From: Laura Gibbons <Laura.Gibbons@arun.gov.uk>
Sent: 30 March 2022 14:08
To: Planning.Responses <Planning.Responses@arun.gov.uk>
Cc: Simon Davis <Simon.Davis@arun.gov.uk>
Subject: RE: Planning Consultation on: Y/32/22/DOC

Engineers Comments Regarding Surface Water Drainage

Application No: Y/32/22/DOC

Site Address: 10 Acre Field Grevatts Lane West Yapton Bognor

Project No.	Originator	Volume	Lvl/Loc	Type	Role	Number	Rev
13591	CRH	XX	XX	DR	C	5050	P6

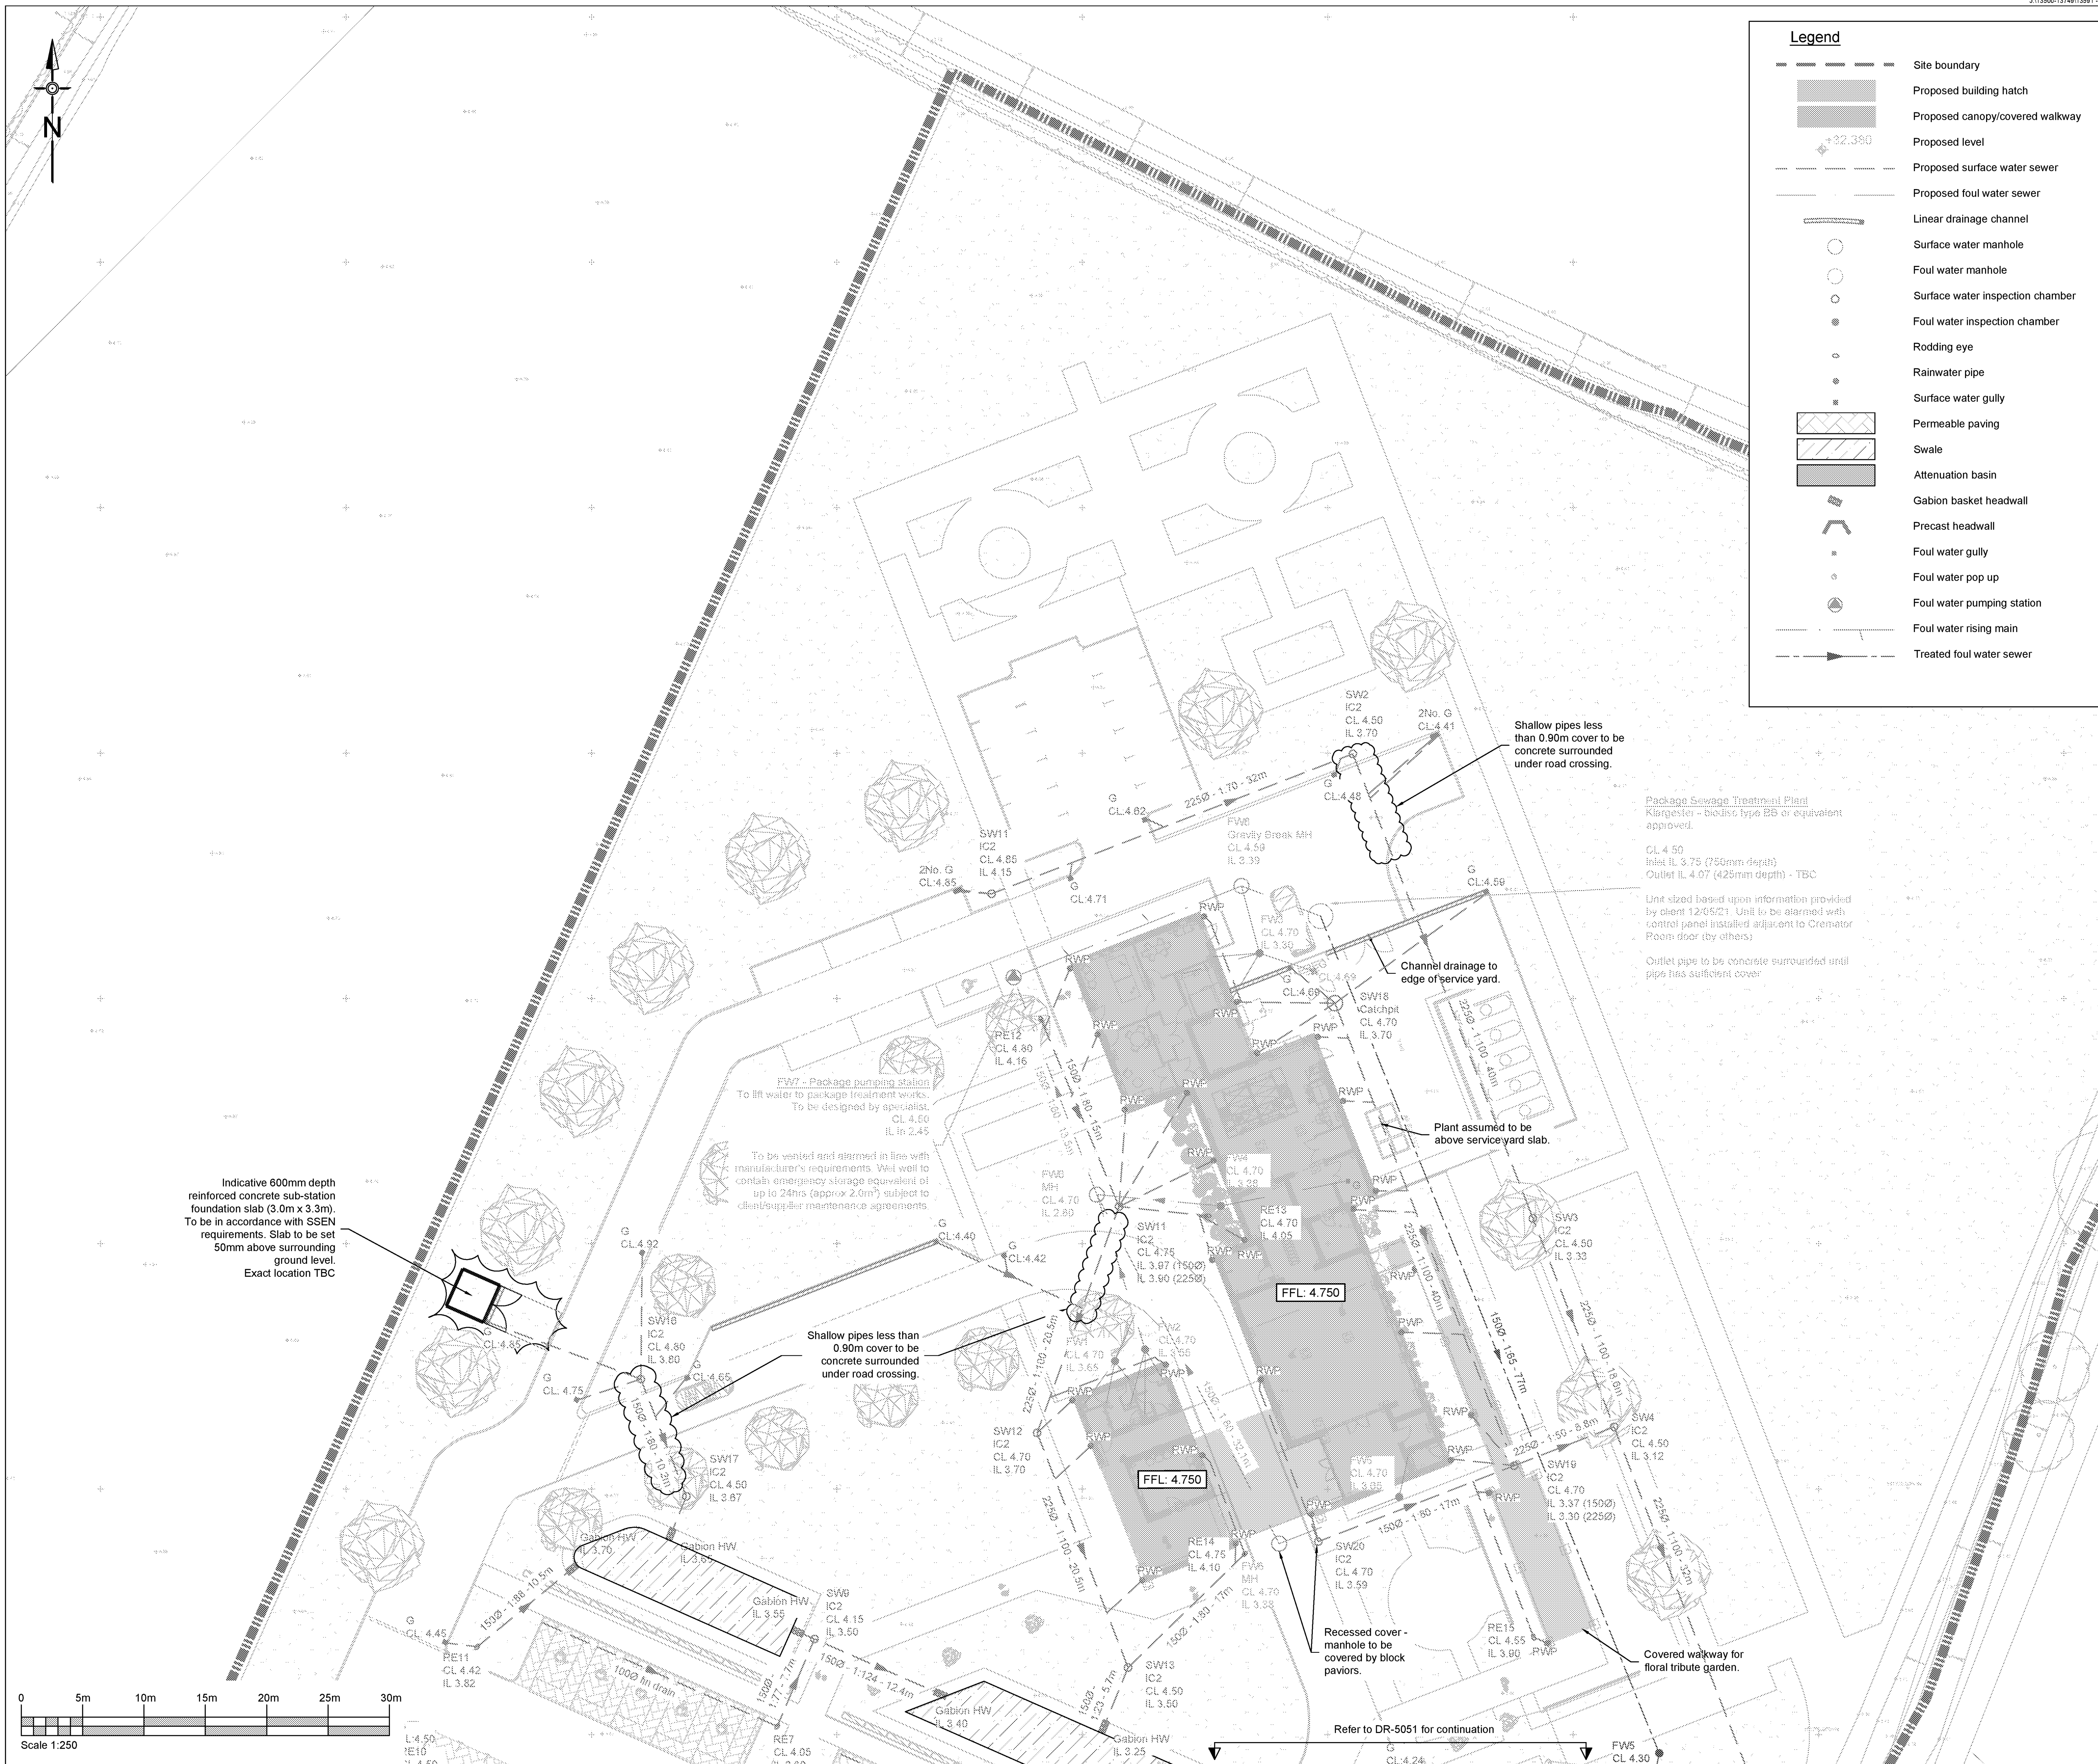
3. **Please supply an impermeable area catchment plan.** Please see enclosed impermeable area plan 13591-CRH-XX-XX-DR-C-5250 Revision P1. Okay.
4. **Please label all pipes with diameter and fall.** Additional pipe labels have been added to drainage layout plans 13591-CRH-XX-XX-DR-C-5050 Revision P6 and 5051 Revision P5. Gradients for short (<5m) pipe lengths have not been shown. Pipe sizes, maximum grades and materials are to be as specified on drainage notes drawing 13591-CRH-XX-XX-DR-C-5300 Revision P1 previously provided. Okay.

7. **Gullies and channel drains should be labelled with cover levels.** Cover levels have been provided for proposed gullies on updated drainage layout plan 13591-CRH-XX-XX-DR-C-5050 Revision P6 and 5051 Revision P5. Channel drain cover levels will necessarily vary along the length and hence have not been provided. Exact levels will be determined by contractor to suit the finished levels as shown on levels plan 13591-CRH-XX-XX-DR-C-5200 Revision P3. Levels should be provided on plan to ensure construction is carried out in accordance with proposals.

Project No.	Originator	Volume	Lvl/Loc	Type	Role	Number	Rev
13591	CRH	XX	XX	DR	C	5051	P5

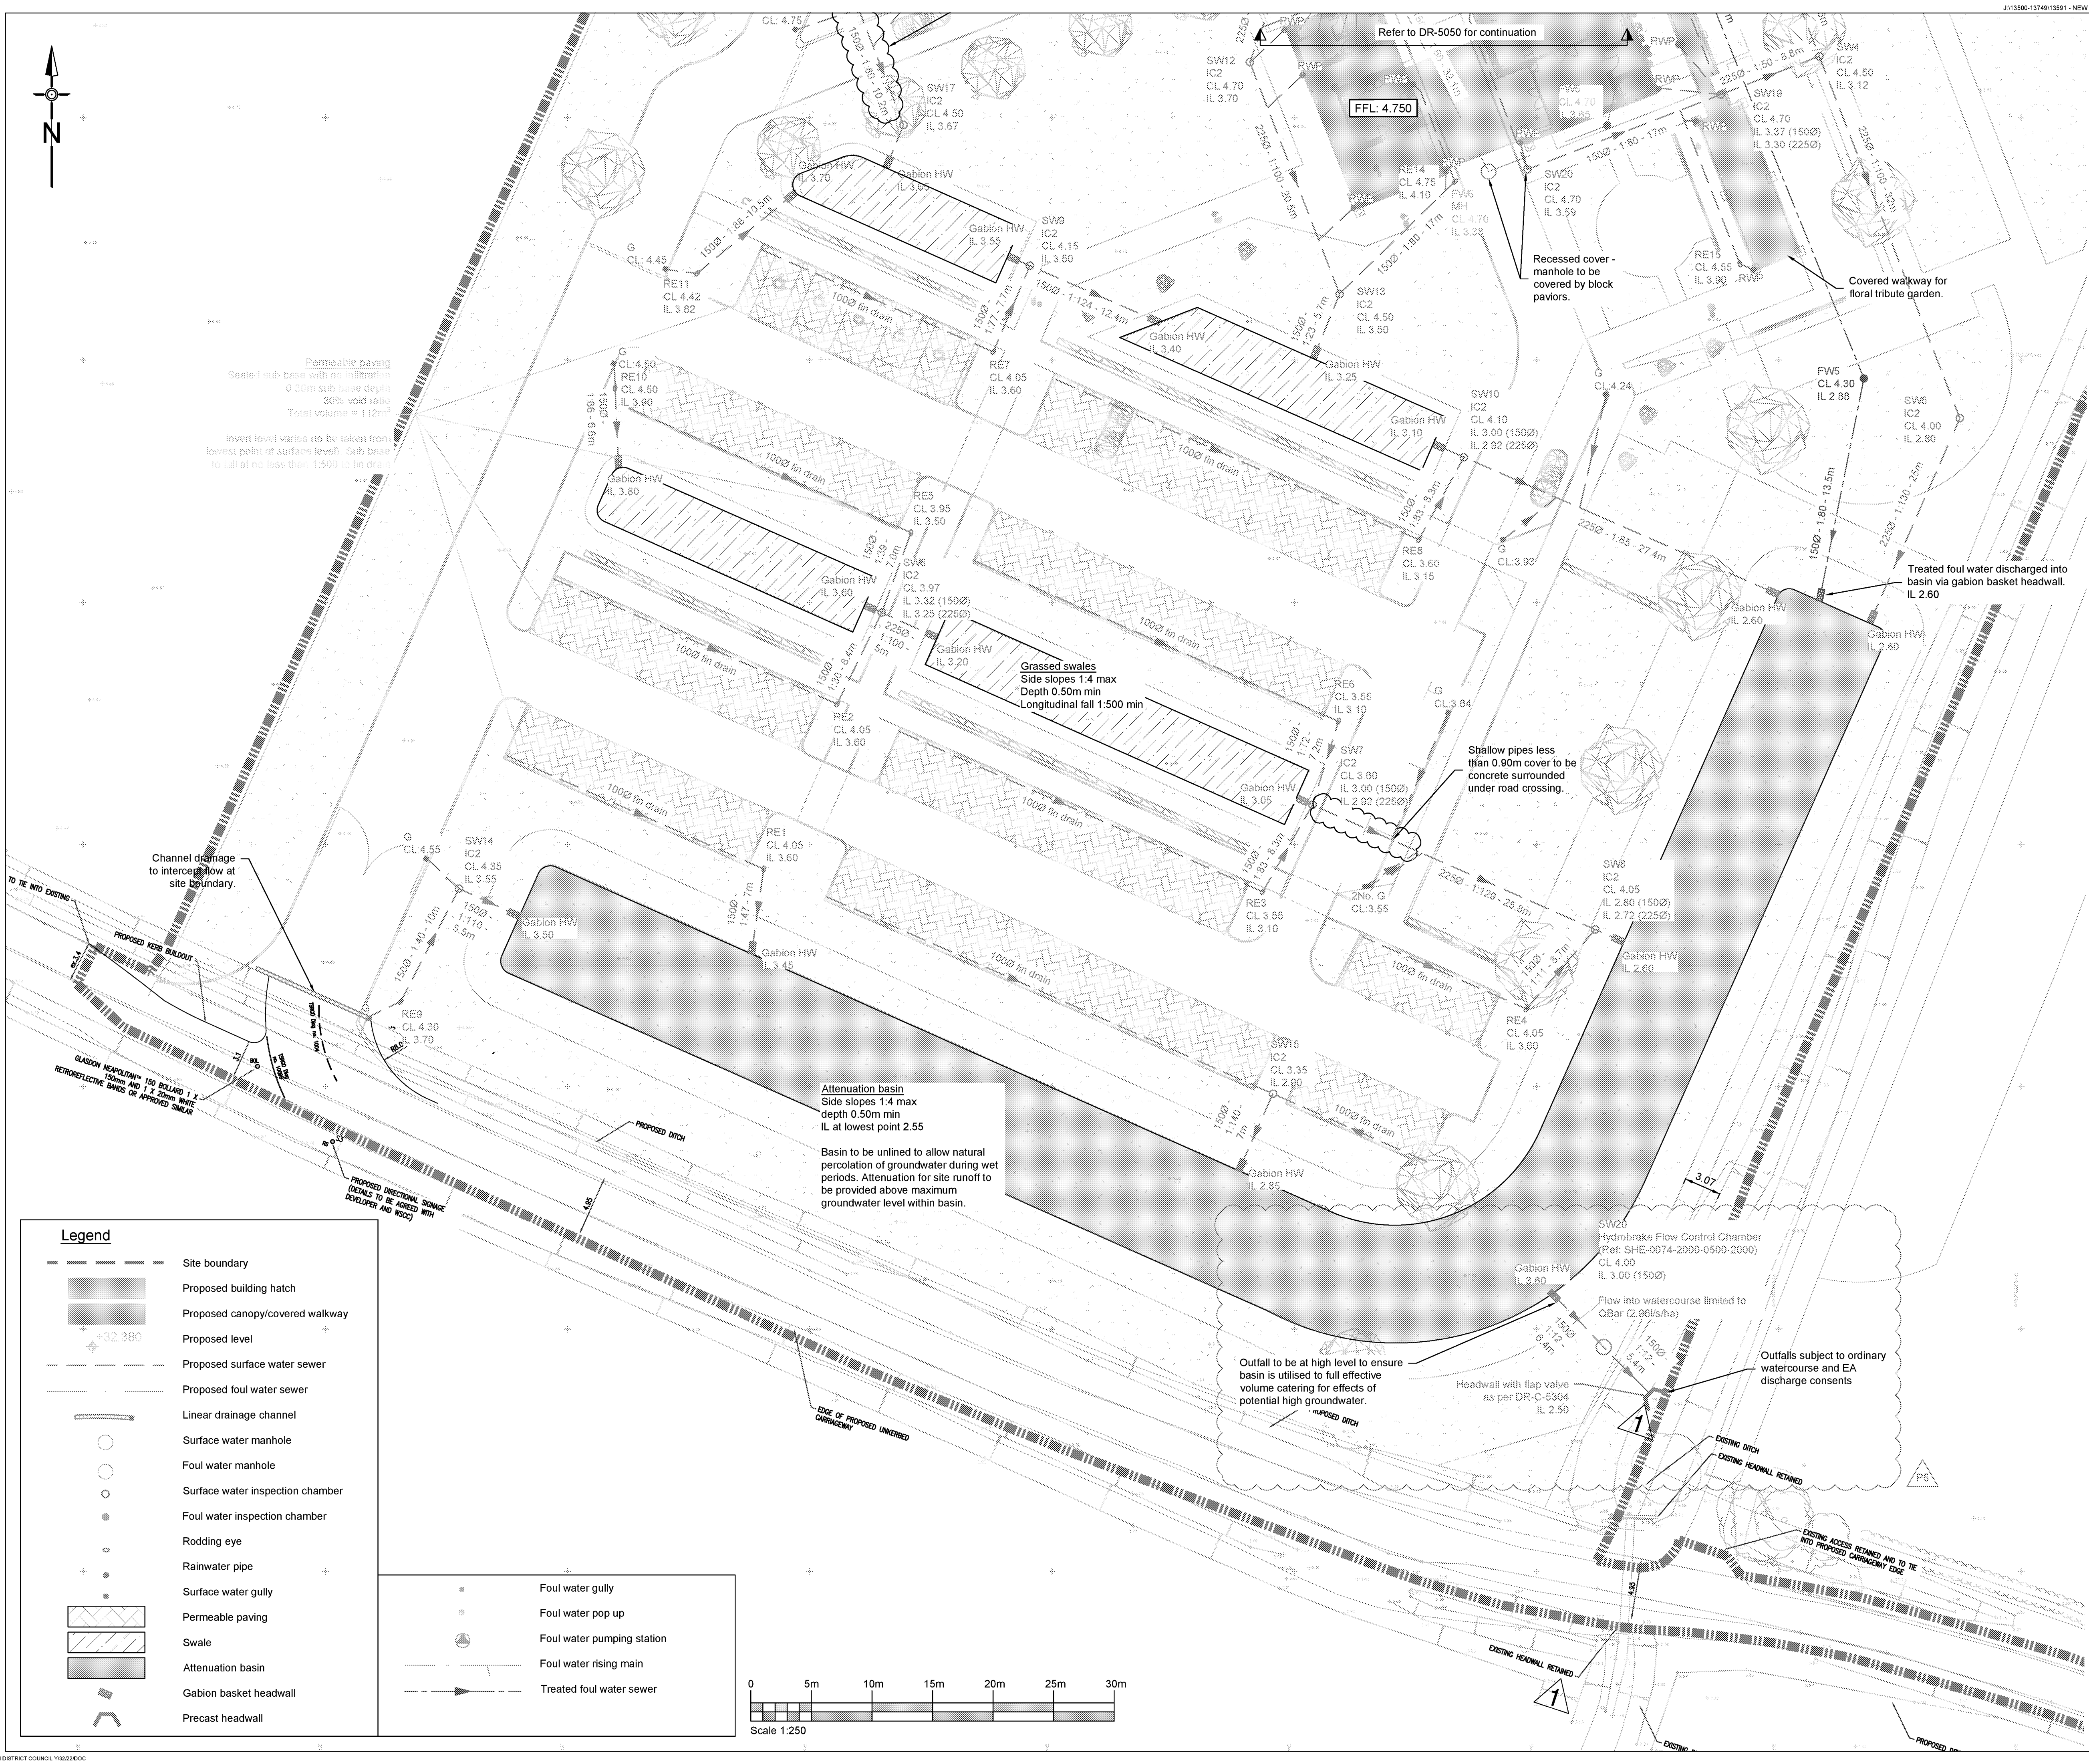
5. **Hydrobrake unit references should be included on layout plans.** Details have been added to updated drainage layout plan 13591-CRH-XX-XX-DR-C-5051 Revision P5. Okay, but please see comment above for more detailed calculations to evidence a compliant design.

2. *Please supply a buffer plan to show that at least 3m is being provided between top of bank of watercourses and obstructing features, such as fences, buildings, and basins. A suitable buffer has been provided between top of basin and edge of watercourse to allow for maintenance, as shown on drawing 13591-CRH-XX-XX-DR-C-5051 Revision P5. Buffer not clearly shown, please show the buffer on a plan.*
